From: Amanda Scholes on behalf of Planning.Responses
Sent: 24 October 2017 09:06
To: Planning Scanning
Subject: FW: AW/155/17/PL---Brus Lodge, 28 Kingsway, Craigweil---OBJECTION
Attachments: 28Kingsway(BrusLodge)SA-AW-155-17-2.doc

Regarding Planning Application AW/155/17/PL for Brus Lodge, 28 Kingsway, Craigweil.
Please find attached a **Letter of OBJECTION** to this application of several grounds, for publication of the District's website.

Having studied the recent submissions by the Applicant's Agent, amending the details of the front garden and front boundary treatments, I wish to OBJECT as follows.

Drawing No
LLD856 / 02

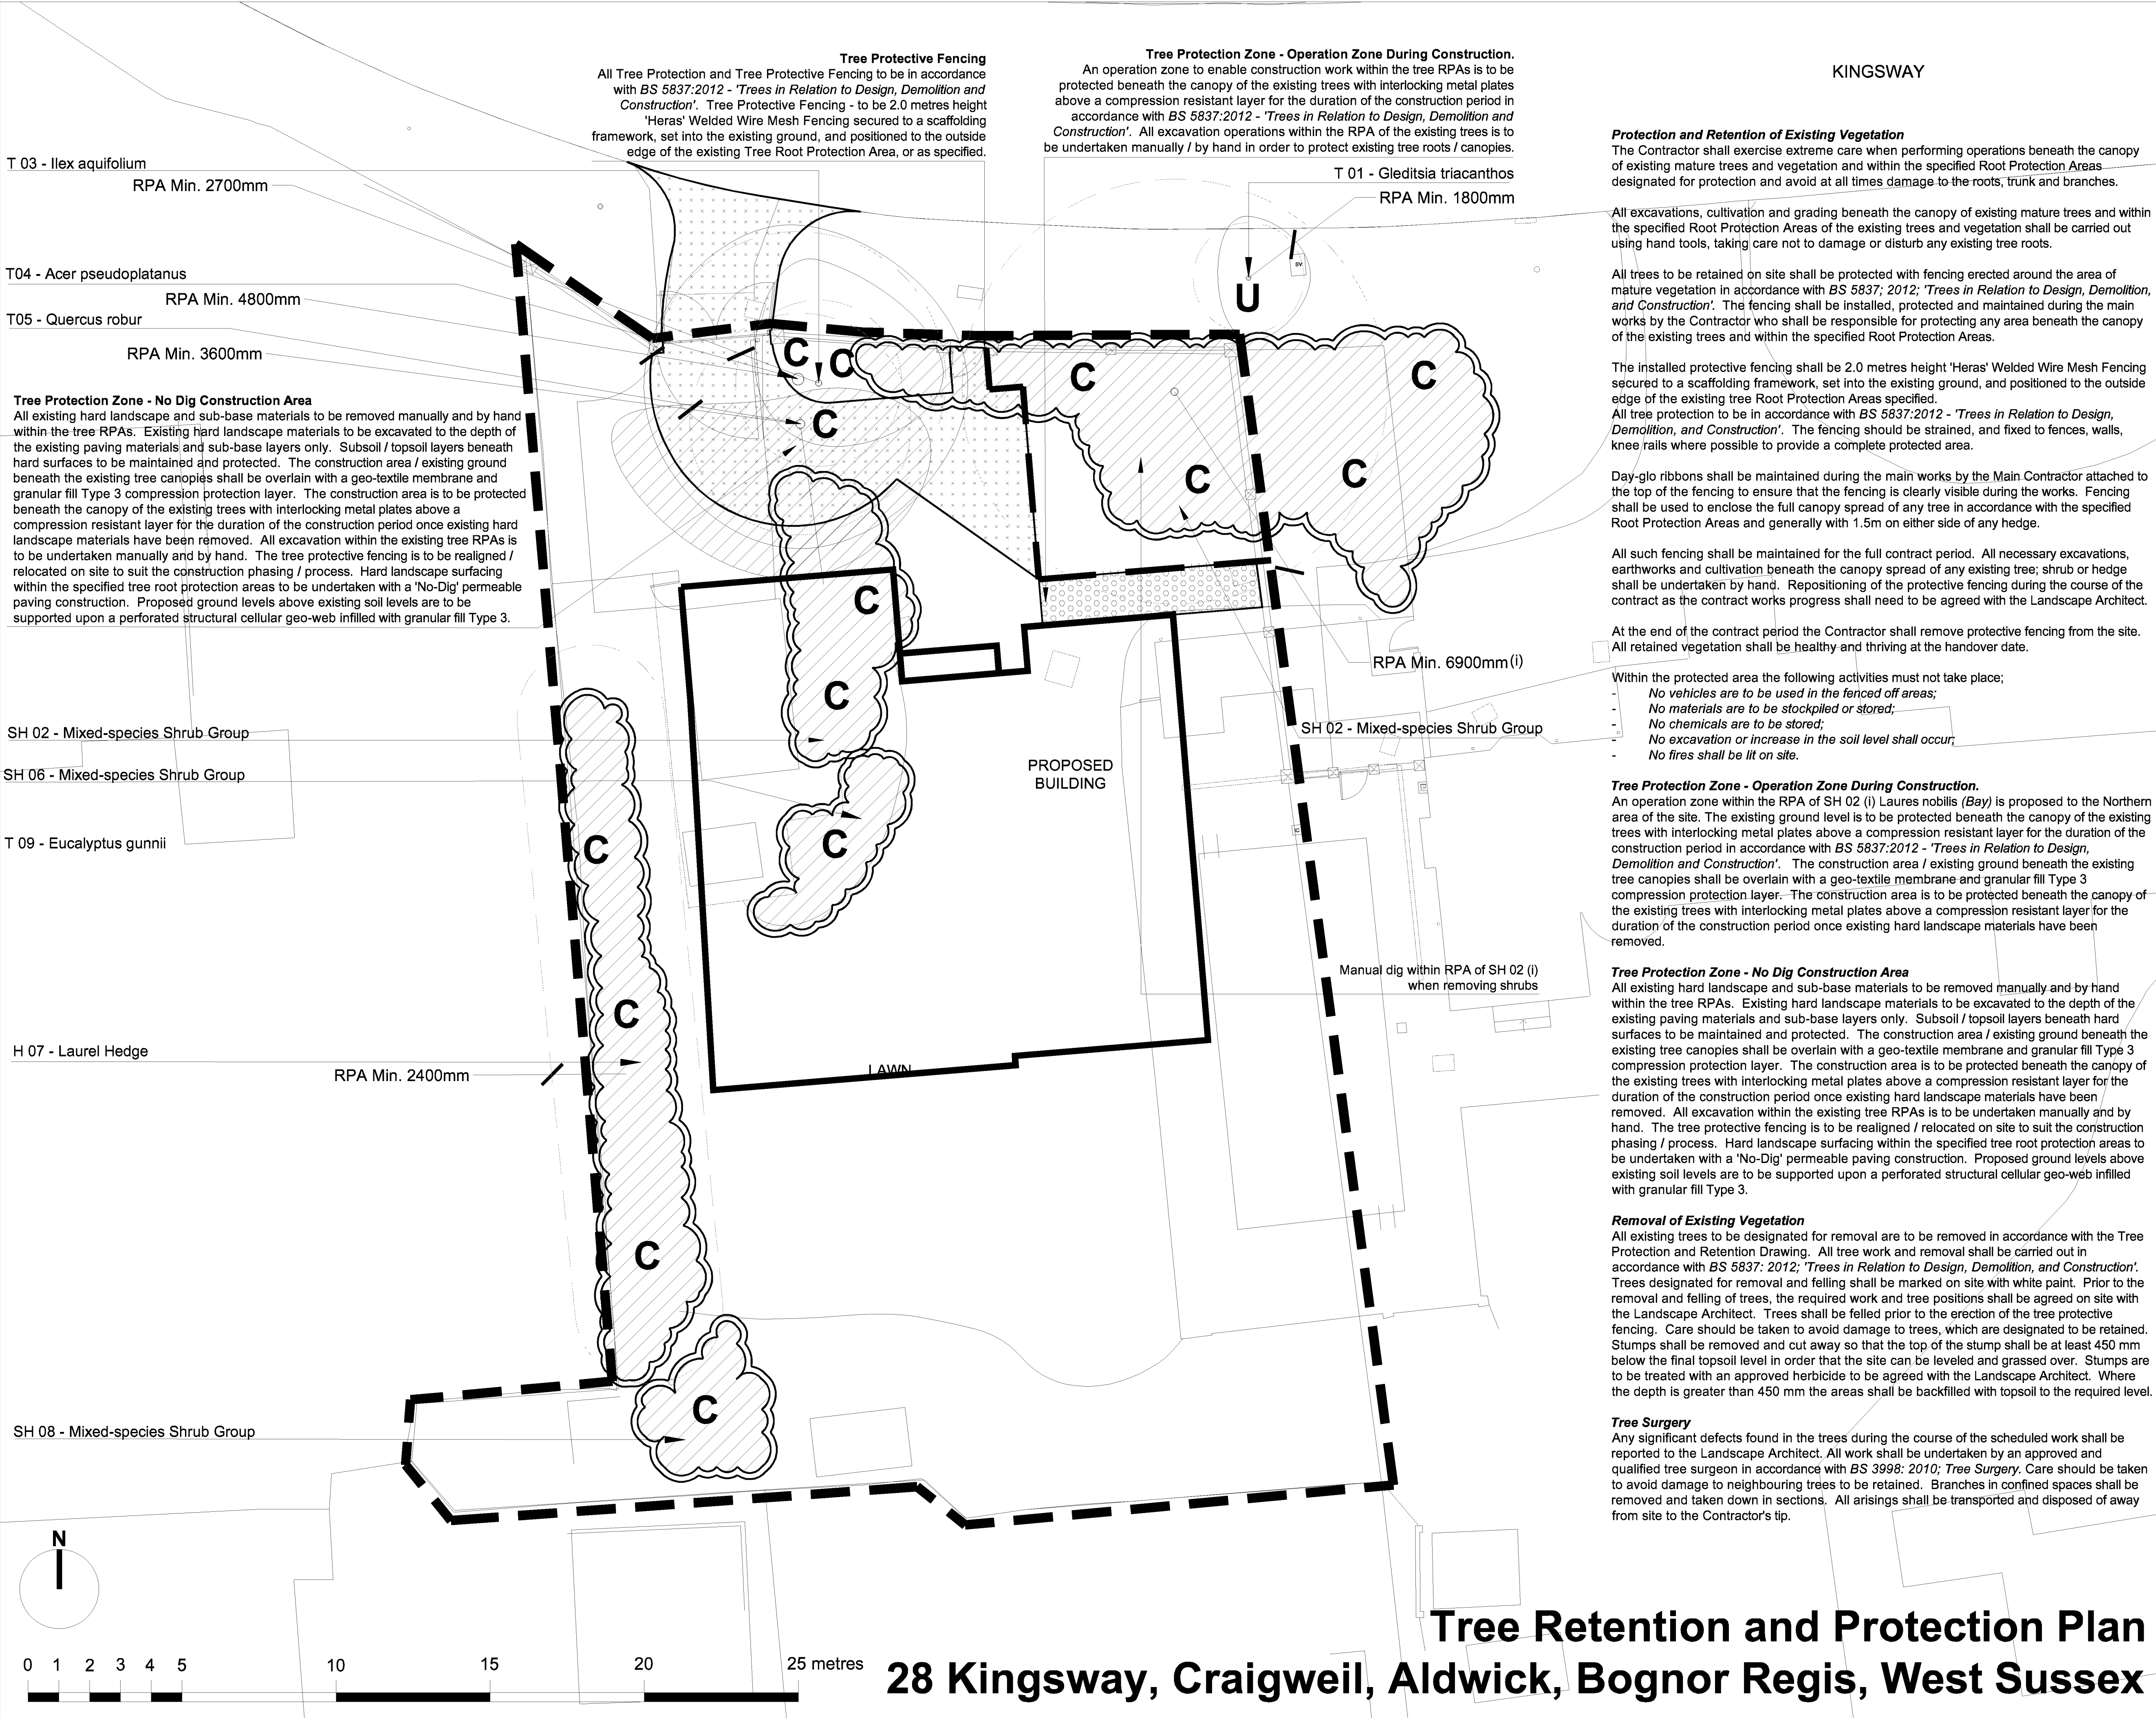
(g) From the drawing LLD856/02 Revision 03, the green line depicting the placement of Protective Fencing makes muddled thinking I believe. There are two clearly defined squares of green lines to

the north of the site, centrally and to the east. HOWEVER, there is then a green line around the east and west boundaries, broken by the strip behind the western shrubbery to be removed. Where this green line negotiates the NW corner of the site, it then crosses the verge outside the land owned by CPEL. This then leaves almost the complete 'roadway/entrance area where site vehicles and equipment will be traversing, open to heavy damage and incorporating the RPA's of trees etc.
